LOWER THAMES CROSSING					
PROPOSED PUBLIC RIGHTS OF WAY					
RESPONSE TO EXA ACTION POINT 9 ARISING FROM ISH10 TRAFFIC & TRANSPORTATION					
CLIENT:		THE MOTT FAMILY			
LTC EXA REF:		AP1308 AP1369			
LTC APPLICATION DOCUMENT:		REP2-073 9.6 Supplementary Walking, Cycling and Horse Riding (WCH) Maps (Volume B)			
PROPOSED NEW PROW	PROW SECTION	FOOTPATH	CYCLEWAY (OBJECTION/NO OBJECTION)	BRIDLEWAY	COMMENT (if applicable)

Drawing title  
**Proposed Walking, Cycling and Horse Riding Routes North of the River 1 of 2**

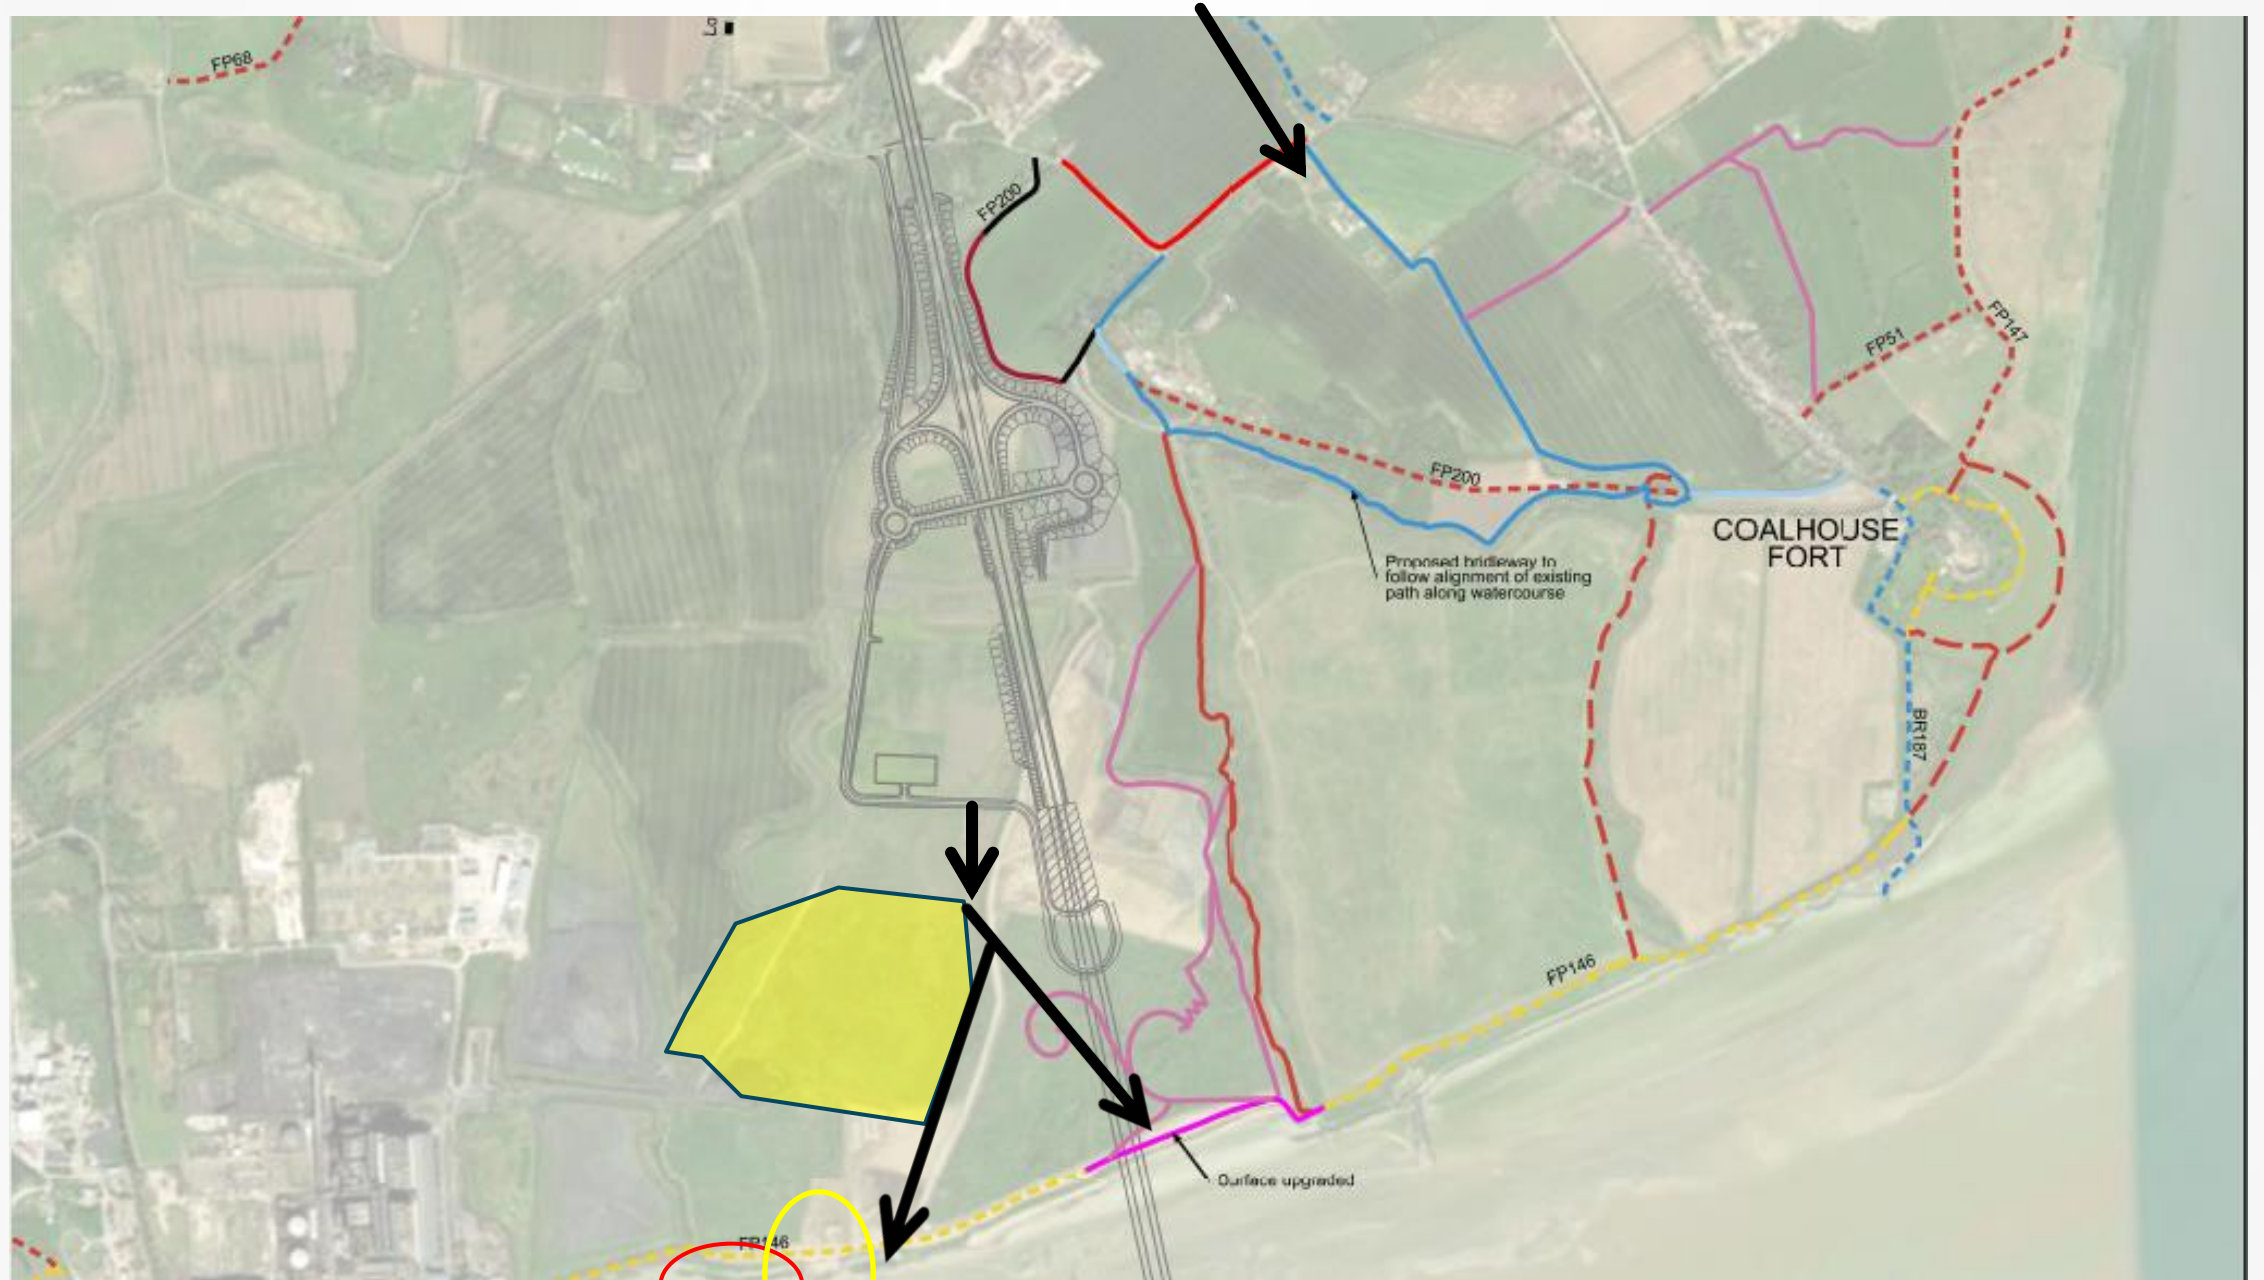
1. Tilbury Fields routes	proposed PROW on eastern boundary linking FP146 (Two Forts Way) and FP200	Objection - see comment	N/A	N/A	A new Coastal Path footpath link was established in 2022 on the route shown coloured red on the Plan below. FP146 and FP200 are therefore already linked.

2. Heritage Trial	permissive PROW to east of East Tilbury	No objection	N/A	N/A	
	permissive PROW to west of East Tilbury connecting to proposed Goshems Link	Objection	N/A	N/A

3. Goshems Link	proposed PROW linking Station Road to FP200	Objection	Objection	Objection	Please refer to ISH10 oral submissions and D6 written representations on issues created by new PROWs/bridleway upgrades

4. Station Road WCH Track		Objection	Objection	Objection	Please refer to ISH10 oral submissions and D6 written representations on issues created by new PROWs/bridleway upgrades

5. FP200 south	proposed upgrade to bridleway	N/A	No objection (subject to suitable structures to prevent unauthorised access being permitted)	Objection	Please refer to ISH10 oral submissions and D6 written representations on issues created by new PROWs/bridleway upgrades. In addition, Natural England also object to the upgrading of FP200 to a bridleway - see 2.1.67 of REP5-039 Deadline 5 Submission - 5.4.1.6 Statement of Common Ground between (1) National Highways and (2) Natural England v3.0 (Clean) and Natural England's Written Representation paragraphs 7.1.8 and 7.3.5 - 7.3.8 REP1-262
